6 November 2013

Jennifer Grotting
15 Ivy Street
Darlington NSW 2008

***Modification Request for the University of Sydney Abercrombie Precinct
Redevelopment: Application Number: MP07_0158 MOD 3***

Title
Scale
Date
Number
0 2 4
10 20m
Ground Floor Plan
MARK UP SET
1:200@A1
11.10.13
4001_DA02-D
© copyright nettleton tribe partnership pty ltd

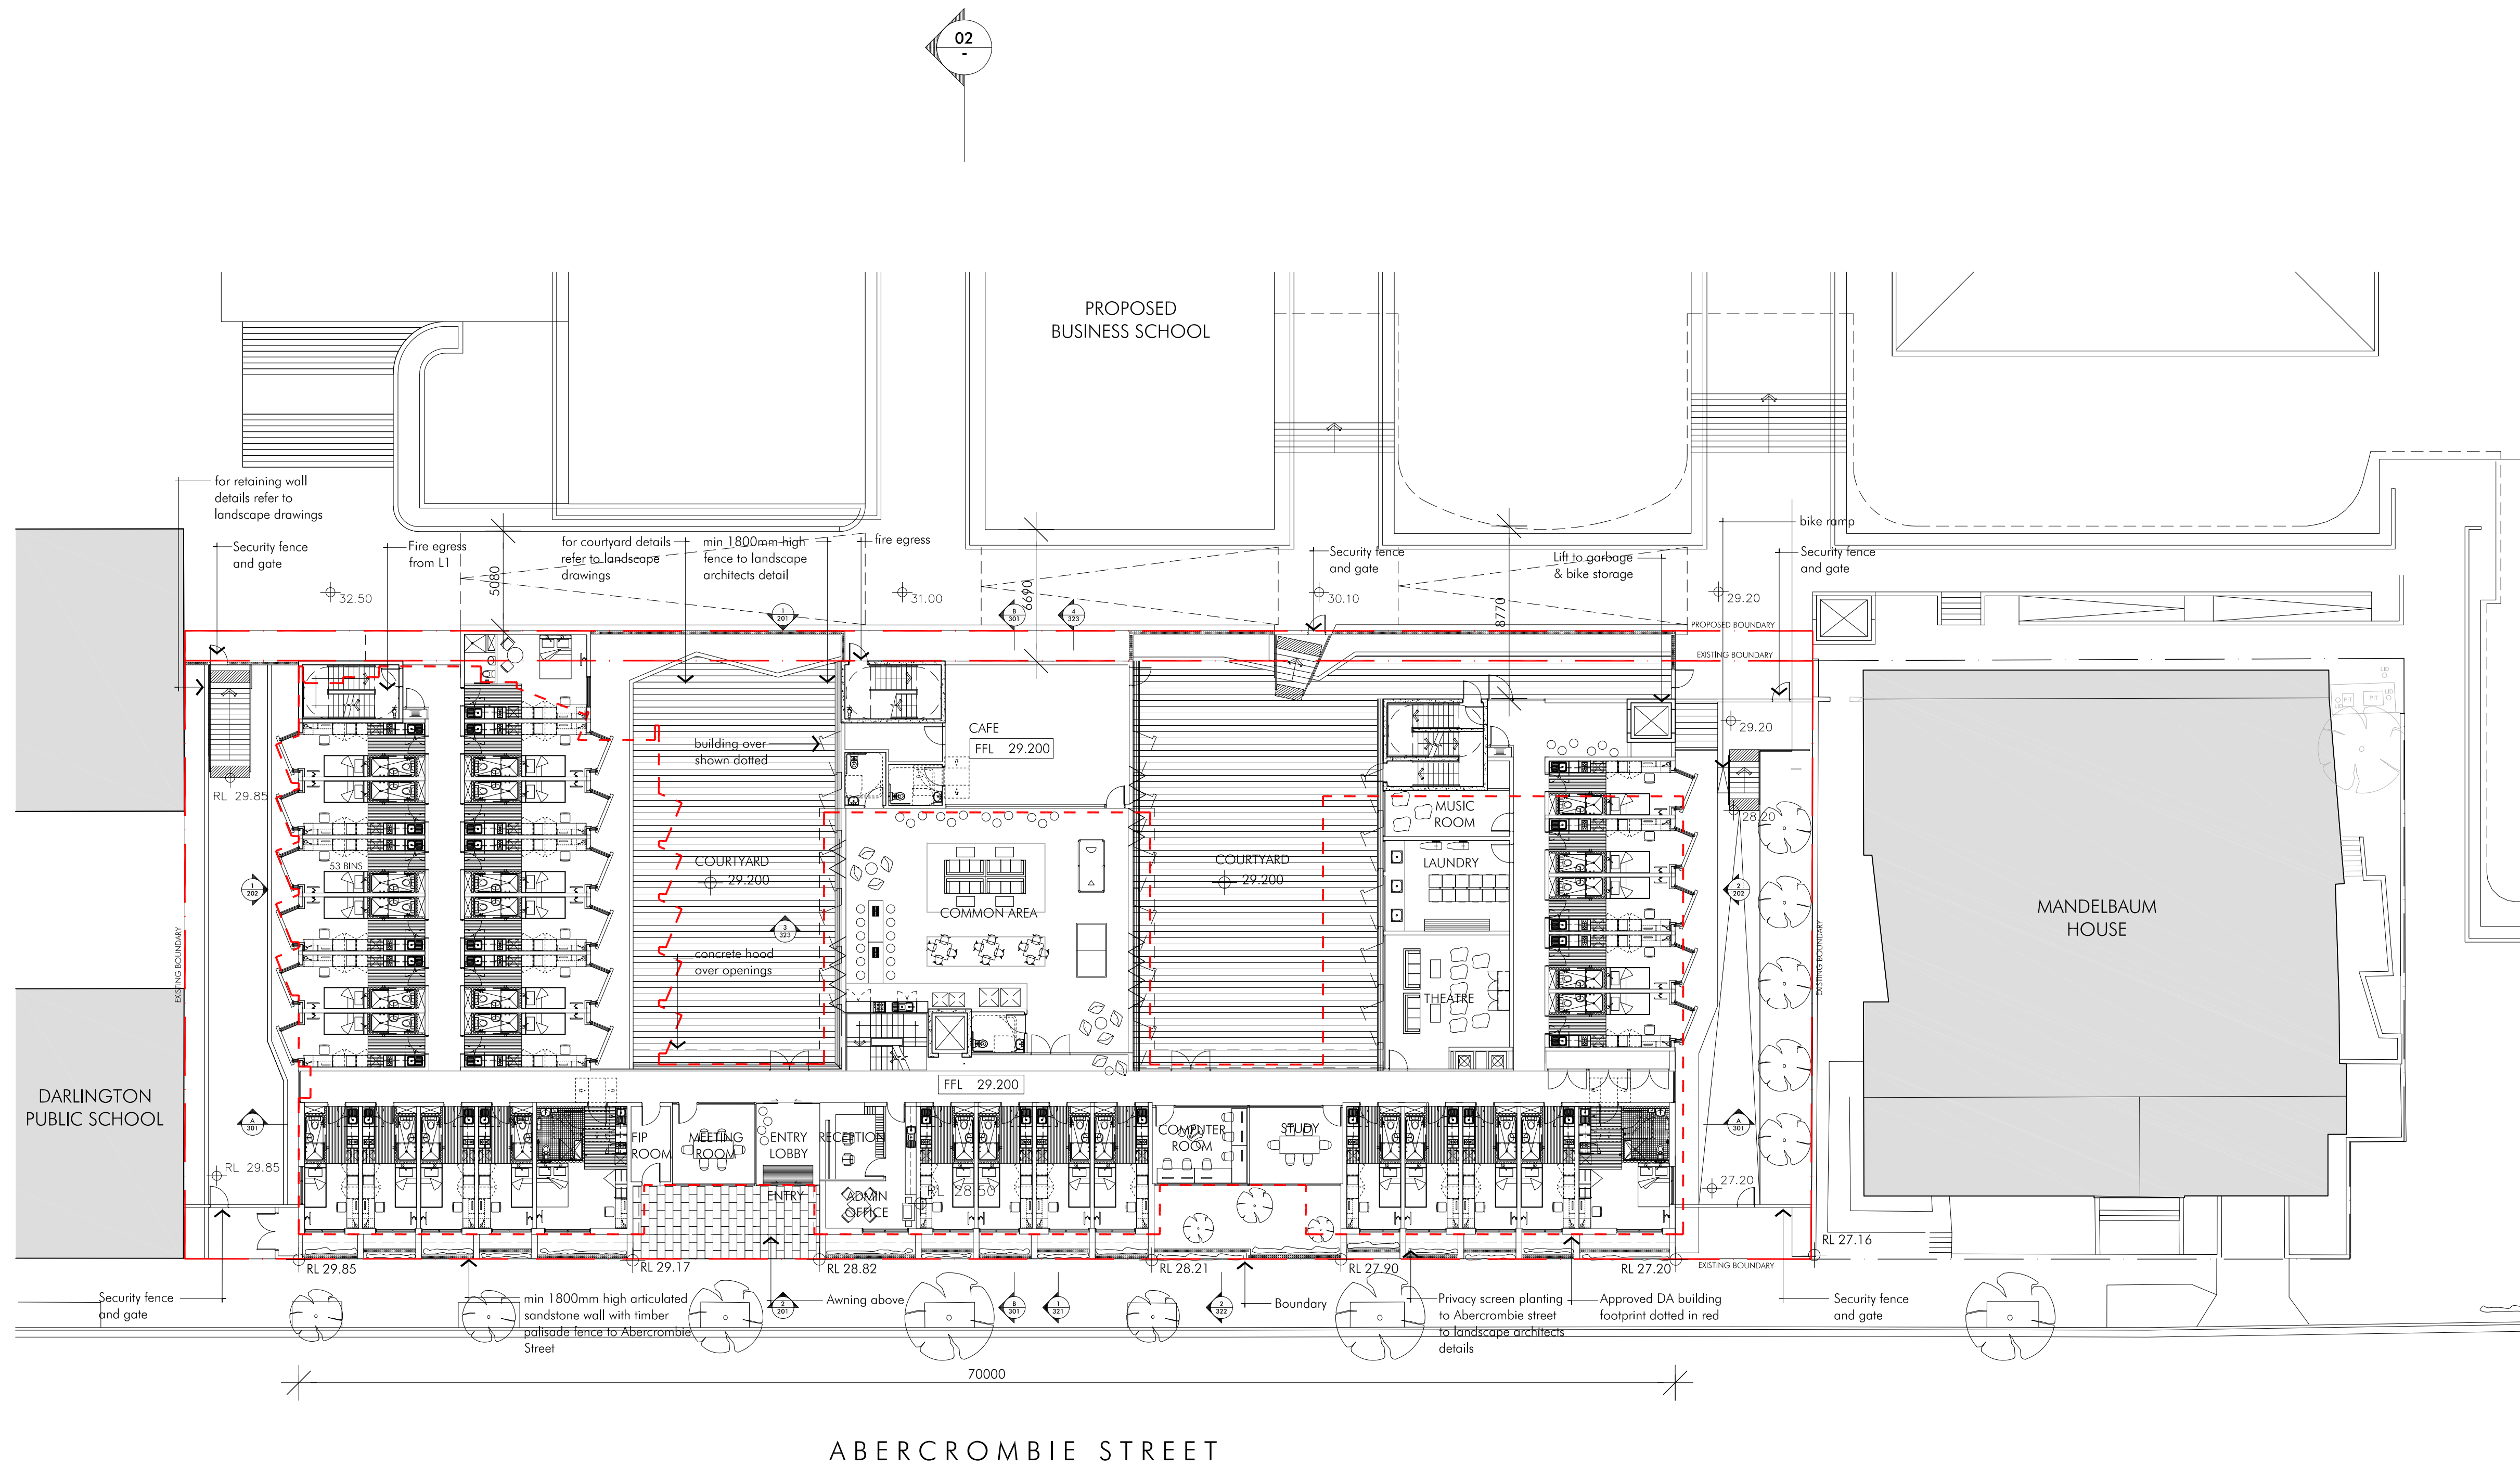
- The front of the Student Accommodation building should be built 2 metres back from the Abercrombie Street boundary. It should be set back from this boundary so that it is in line with Mandelbaum House as it was originally planned and presented to the community. The footprint of the buildings currently on the site, The Shepherd Centre and Boundary Lane Children's Centre, were built approximately 2 metres back from the Abercrombie Street boundary and align with Mandelbaum house. Therefore, the front footprint of the proposed Student Accommodation building should be the same as those buildings occupying the site at present and not be built up to the Abercrombie street boundary.

- The facade of the proposed Student Accommodation building does not reflect the heritage appearance of the Victorian terraces on Abercrombie Street as Mandelbaum House does. Therefore, it should be set back to allow for extensive vegetation and trees to be planted in front of the building on Abercrombie Street to help preserve the heritage streetscape and improve both the aesthetics and the environment of the street.
